Your Ref: OWPC5035
Our Ref: EG/98/14/PL 18-12-2014
Please ask for:
Mr S Davis

Construction of 3 No. two storey detached houses with new access.

Rear of 59 Elm Grove Barnham

Thank you for your internet representation made on 27th February 2015 which has been recorded as '**an objection**' with the comments as follows:

Drawing Title
Proposed Drainage Layout
and Flood Flow Routes

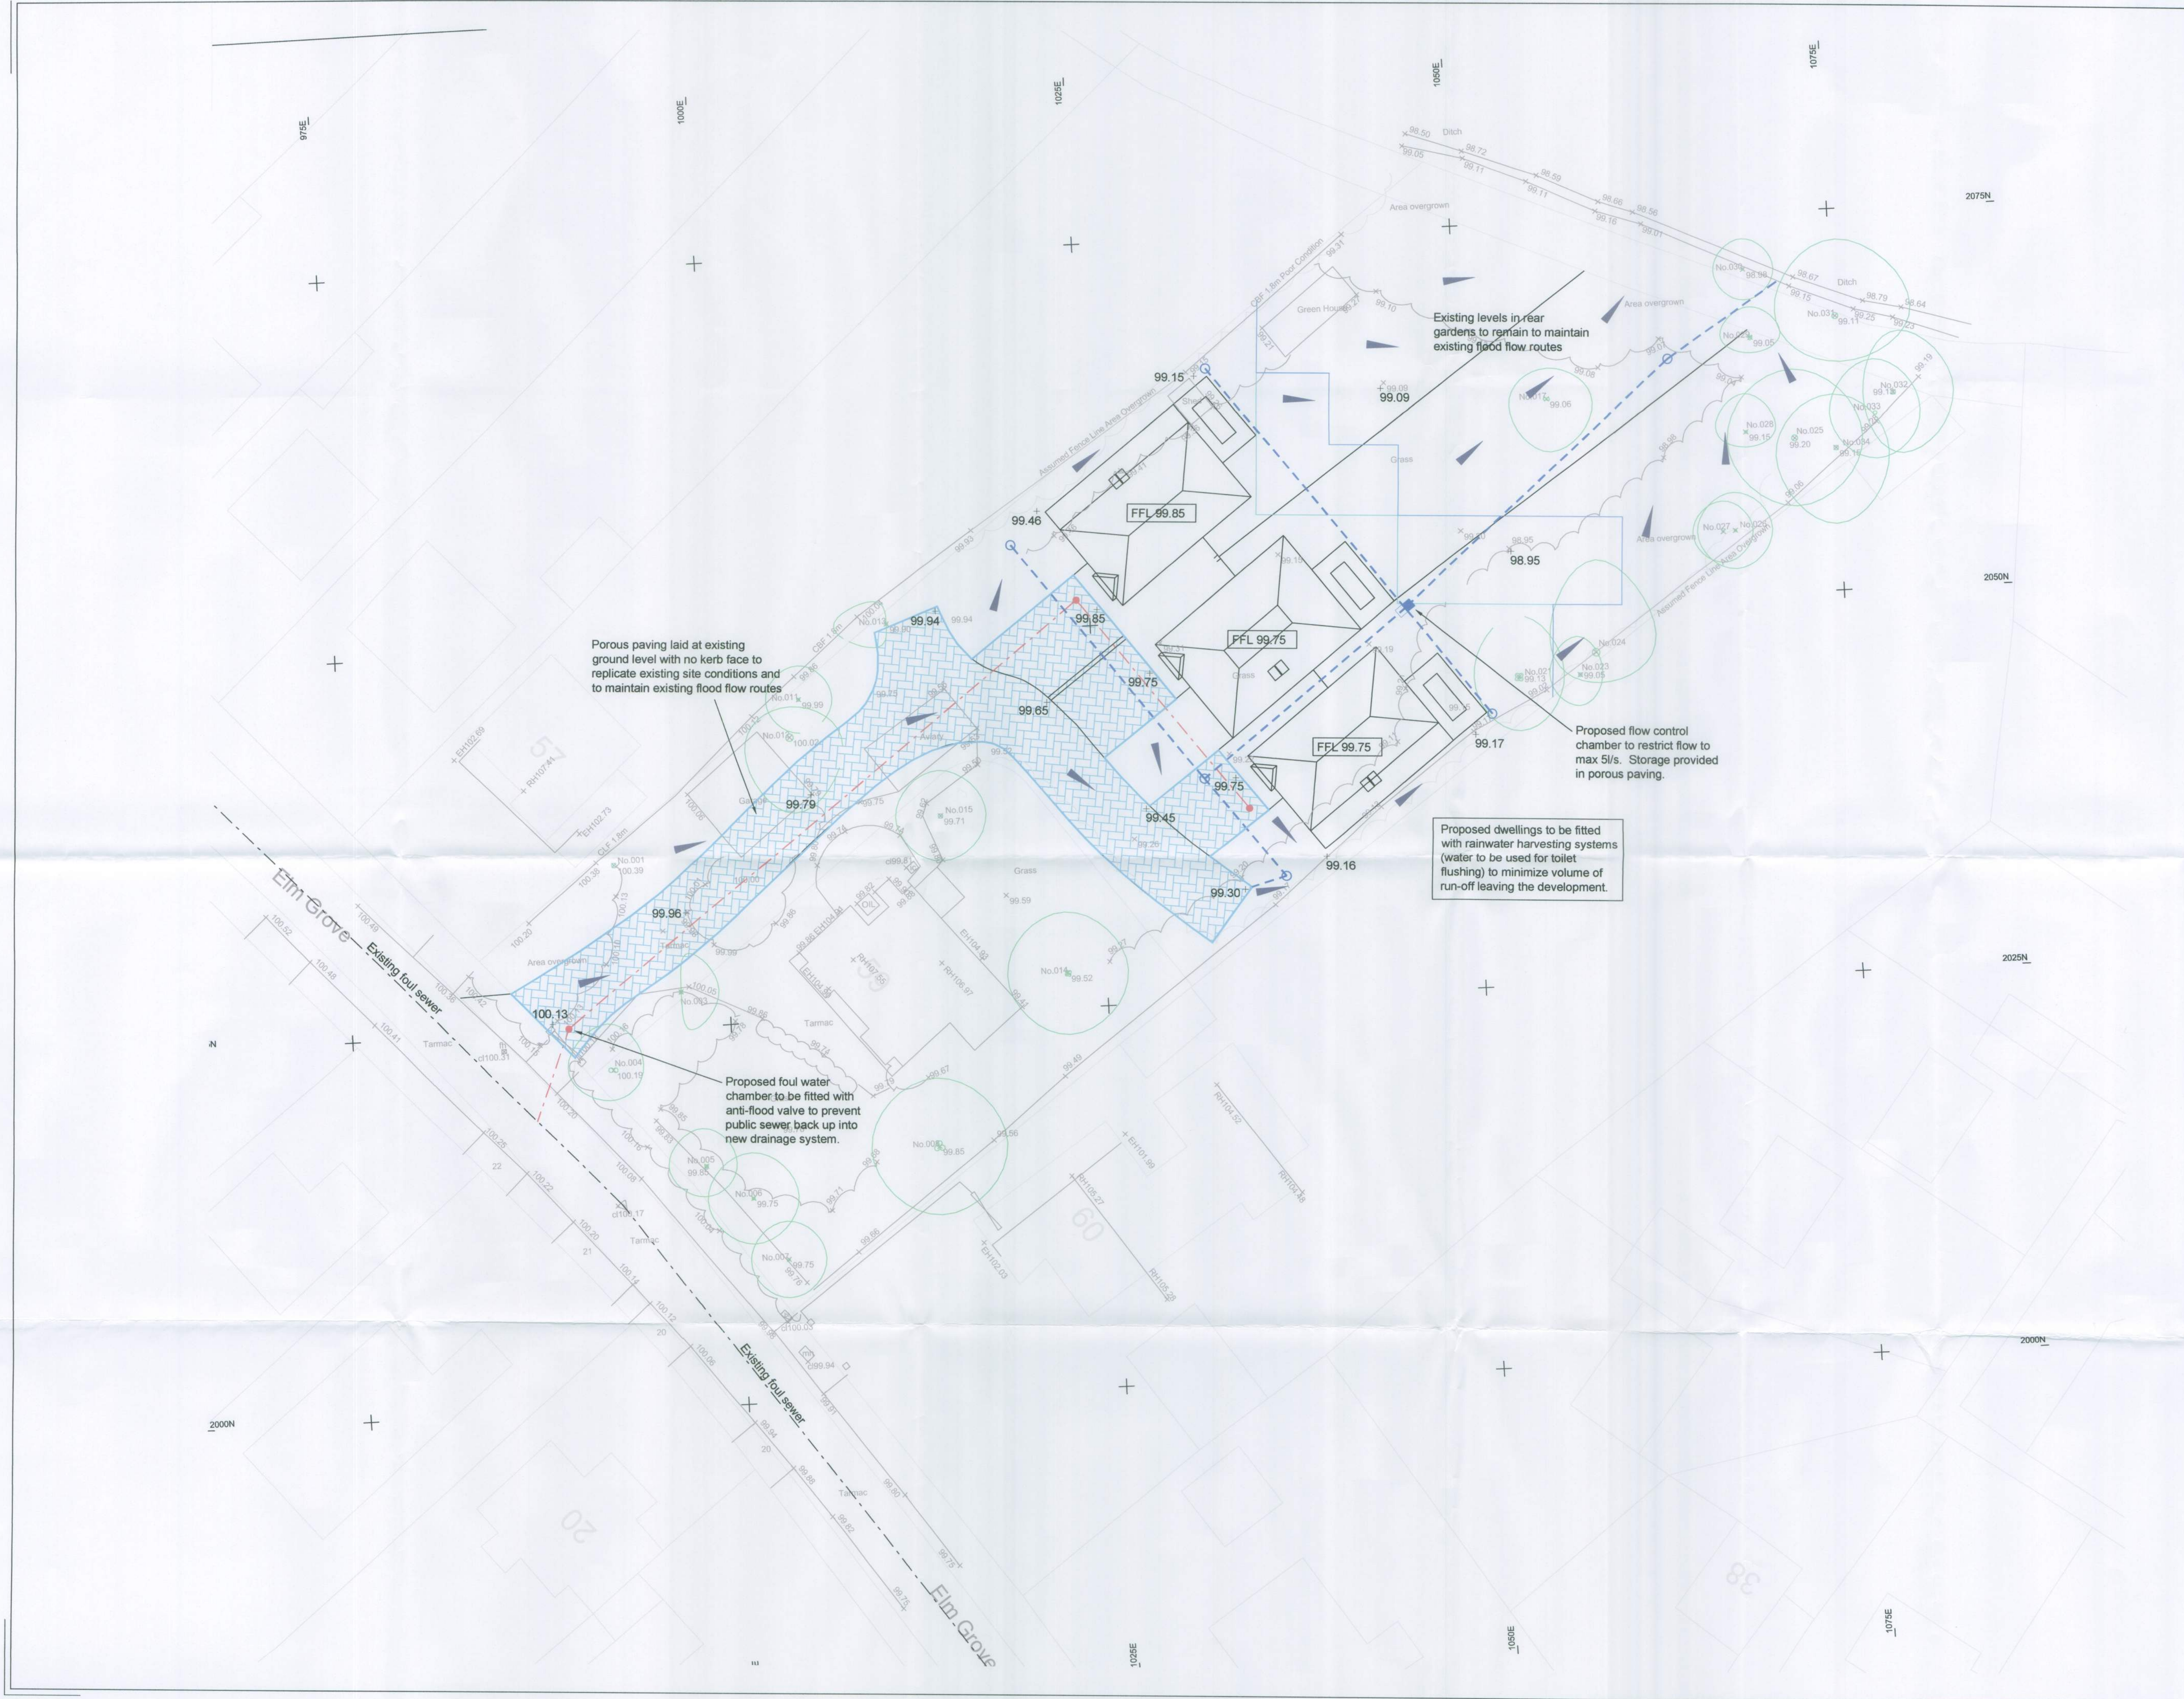
The FRA claims that Groundwater and Surface Water Run-Off can be directed to the watercourse at the north-east of the property (Para. 6.4, 6.5, 8.2, 8.6). This cannot be used to mitigate flood risk. The watercourse is in Flood Zone 3 and regularly breaks its banks when groundwater levels are high and/or during periods of medium to high rainfall.

Various measures are proposed for Surface Water Drainage including Permeable Pavements, Below Paving Storage and Soakaways. These techniques are generally considered not feasible where groundwater is a risk (which the FRA accepts). No
